June 18, 2024

Subject: **CAMA Major Development Permit Modification** for the Proposed Replacement of Bridge No. 9 on SR 1112 (Mouth of The Creek Rd) over Blounts Creek in Beaufort County, North Carolina; TIP No. B-5614; WBS No. 45569.1.2.

The Department requests modification for utilities installation for B-5614.

PERMIT DRAWING
SHEET 2 OF 11

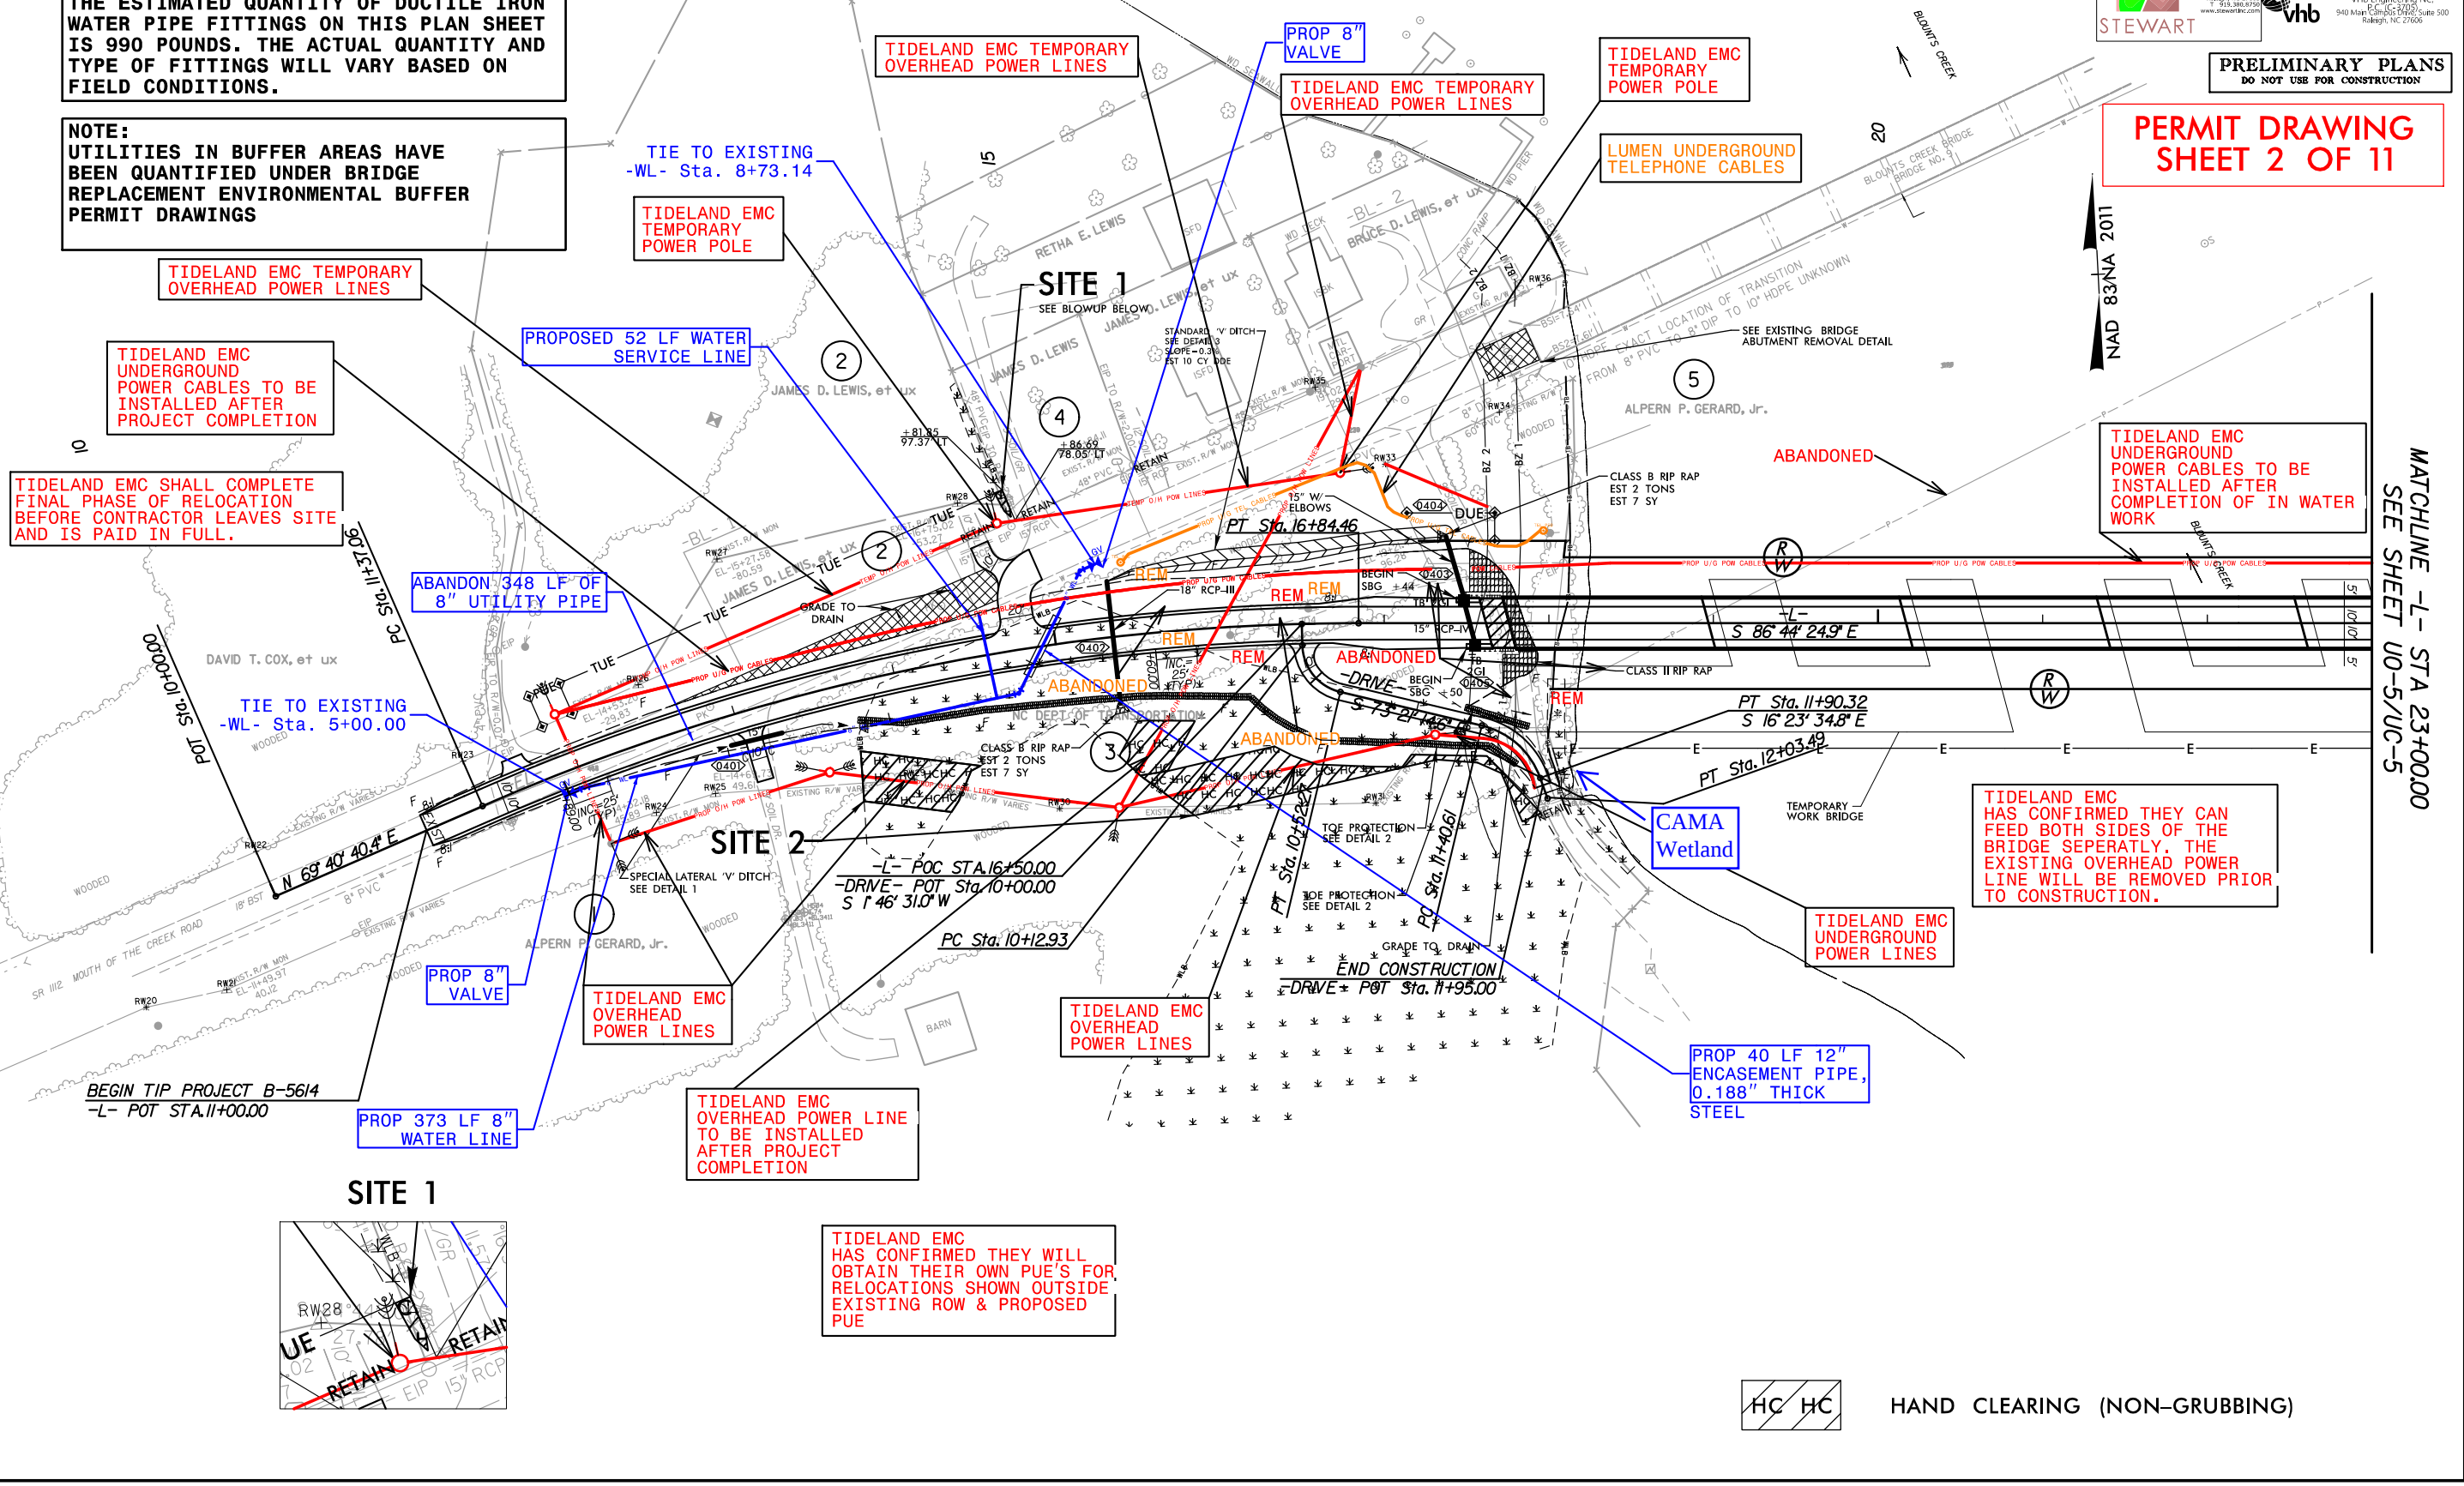
At Site 2, the previously proposed Tideland EMC power pole needs to be shifted to nearby stationing Drive-PT 12+03.49 to accommodate an existing underground line located in the path of the current permitted power pole. The underground line was discovered after the permit was issued.

The new pole placement will be located adjacent to the existing cable and will tie in. The permitted location would have required partially installing underground cable in the wetland to tie to the existing cable and thus create permanent wetland impacts.

The shift of the utility pole location will require an additional 0.01 acres of hand clearing in wetland at Site 2, increasing the total hand clearing impacts from 0.15 to 0.16 acres. The shift of the utility pole will also require an additional 7 square feet of impact in Buffer Zone 2. The increase in buffer impacts at Blounts Creek makes the new total of Buffer Zone 2 impacts 112 square feet. In as much, there will be a reduction in Buffer Zone 1 impacts decreasing from 203 to 0 square feet.

UE-7

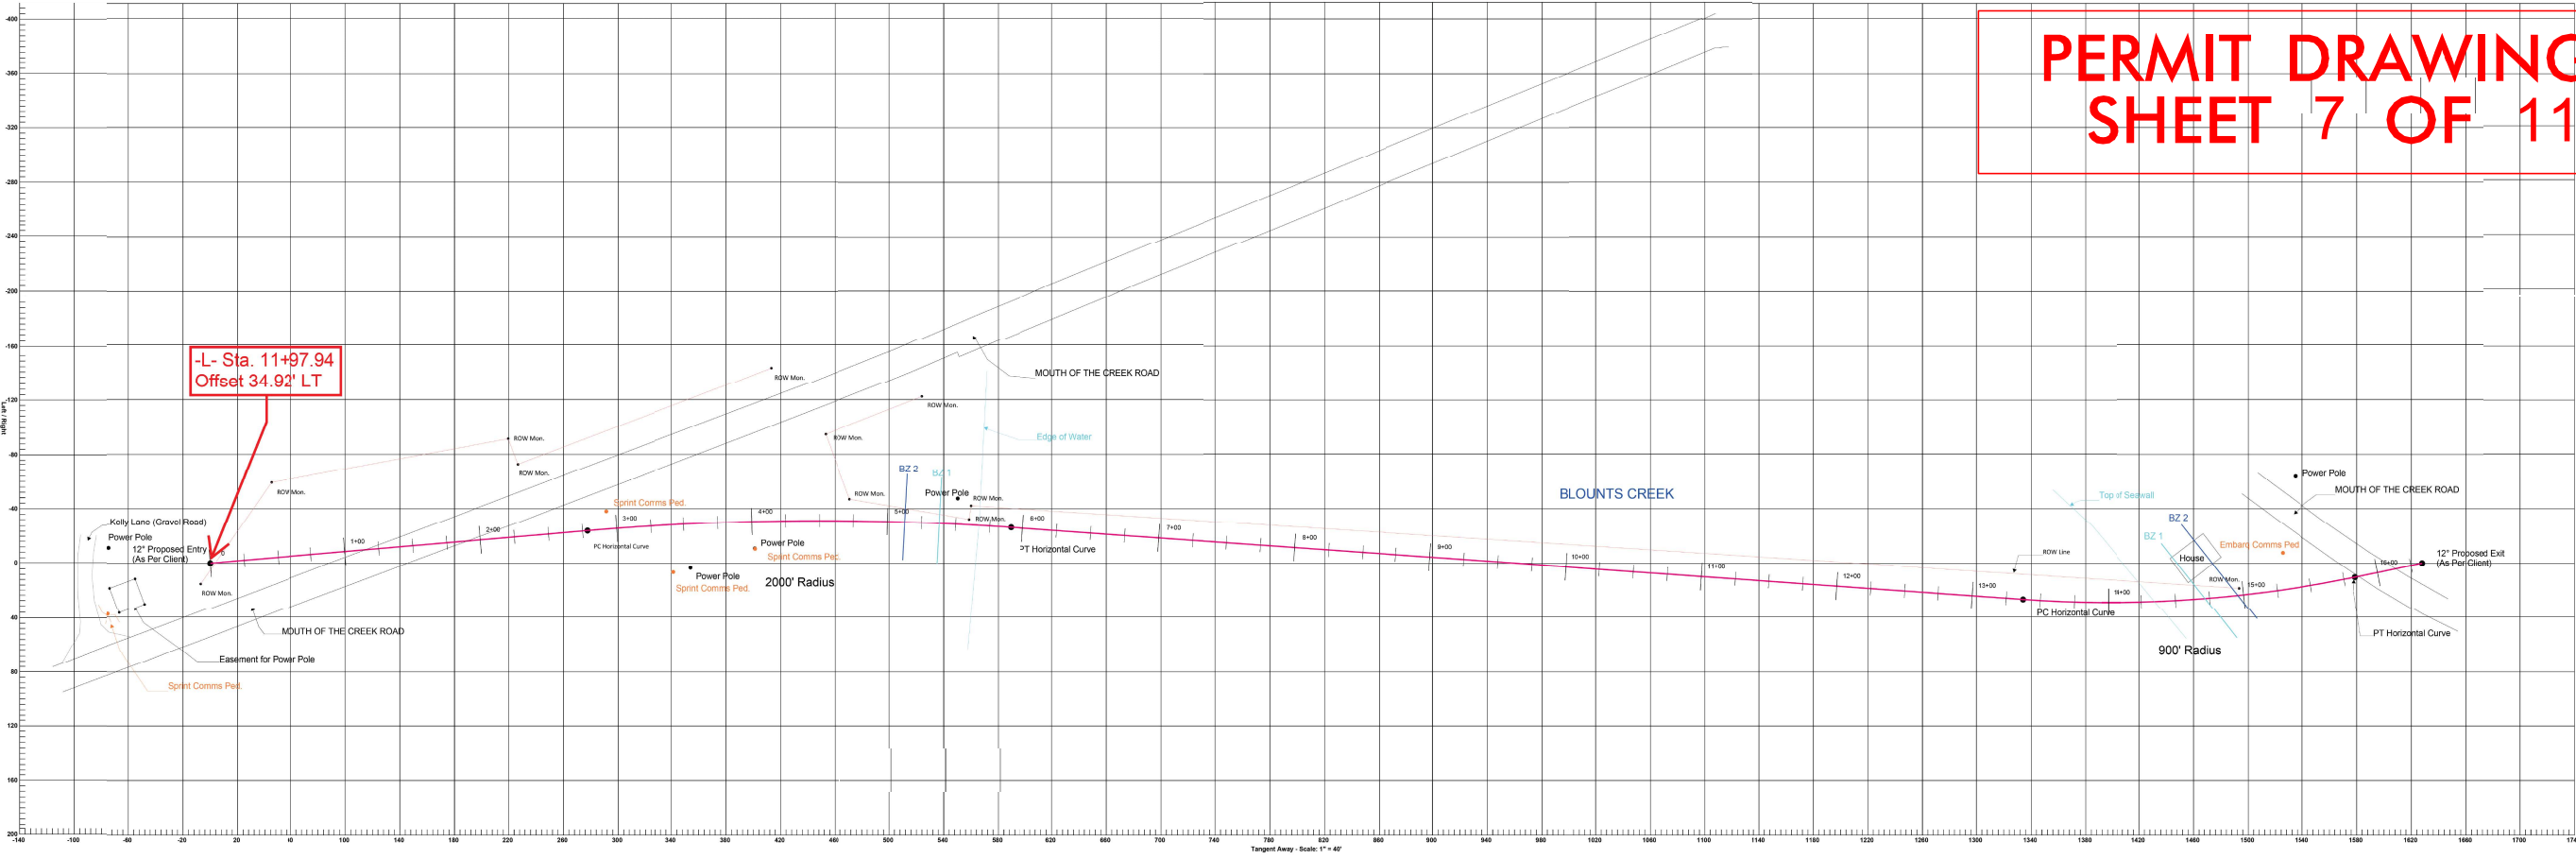
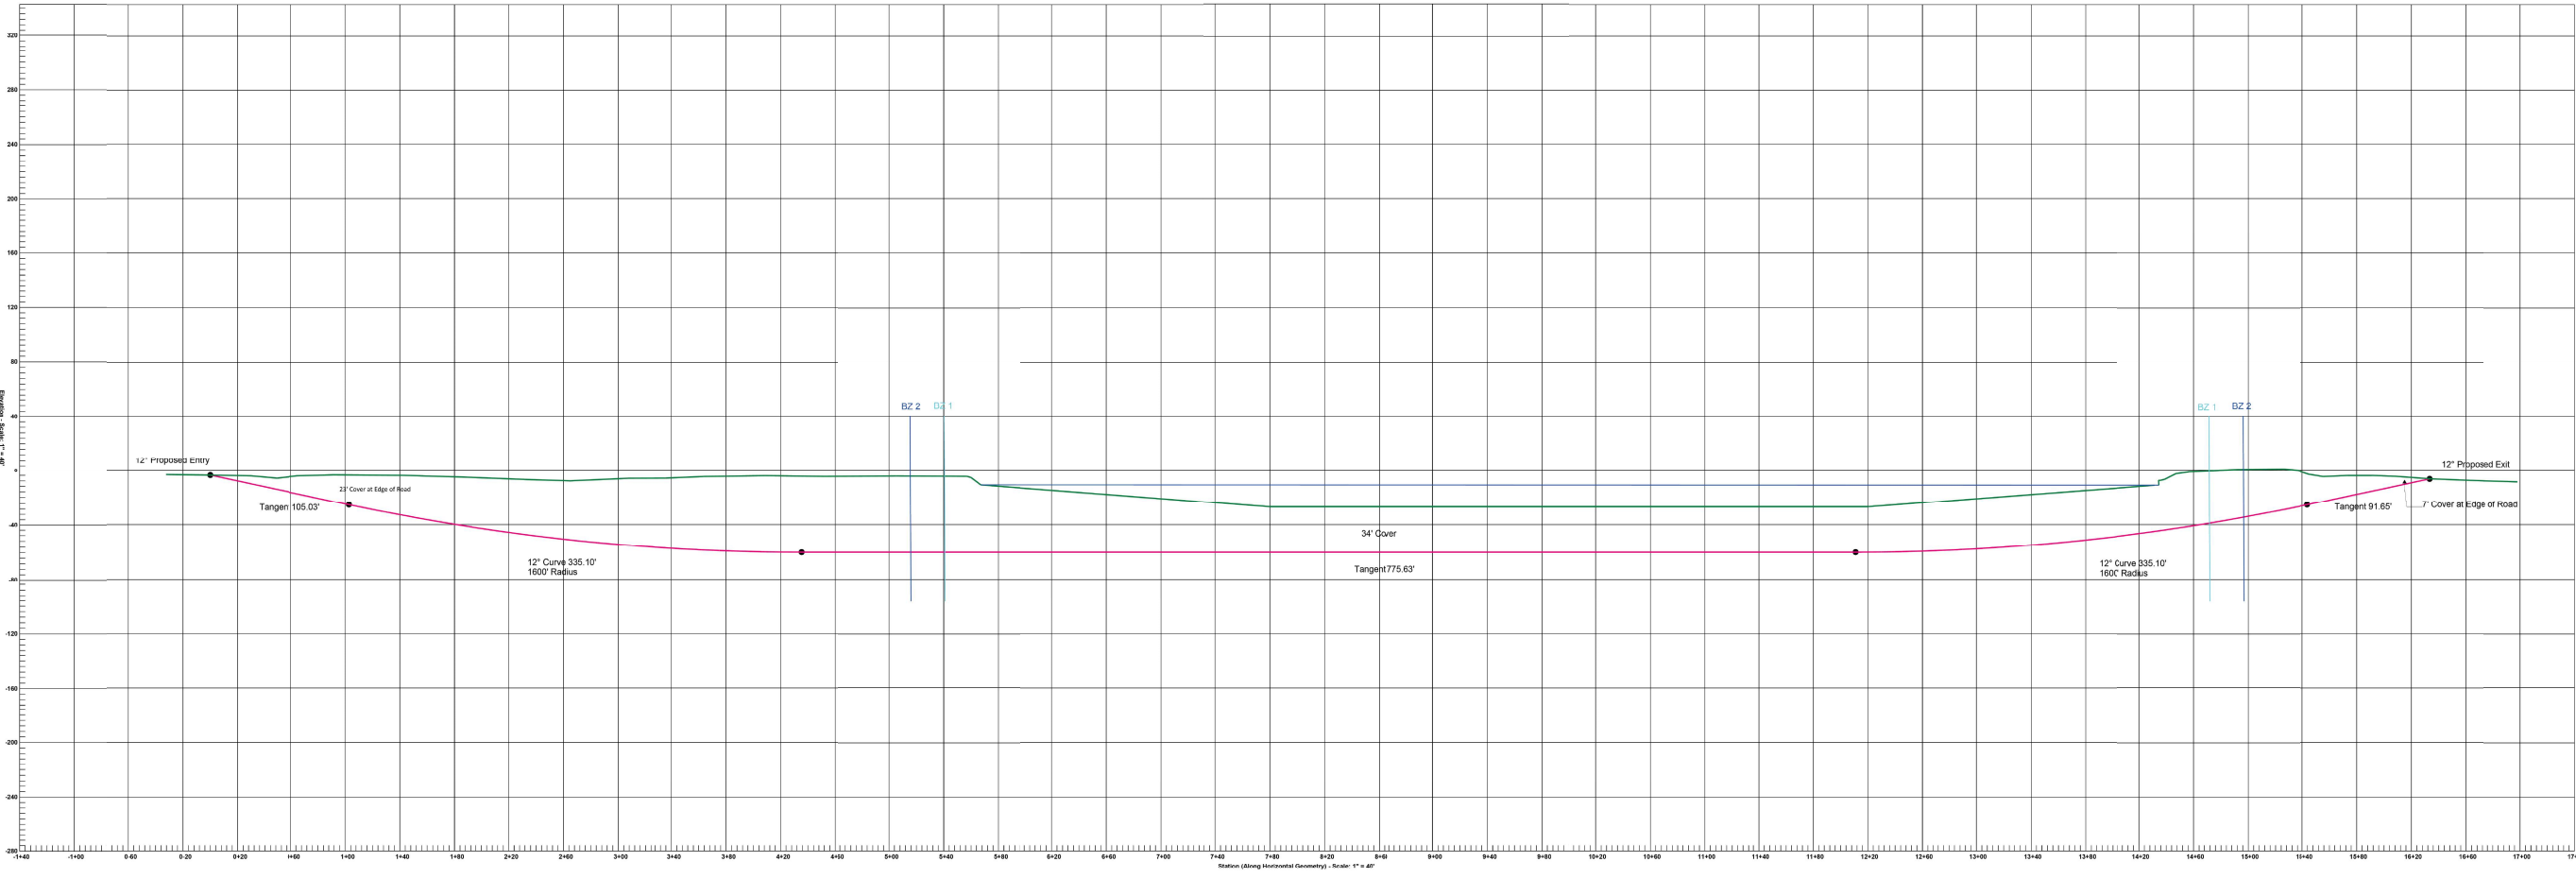
At the bridge, Brightspeed cable will be placed under Blounts Creek instead of terminating at both ends of the bridge. This change will not result in any new impacts.
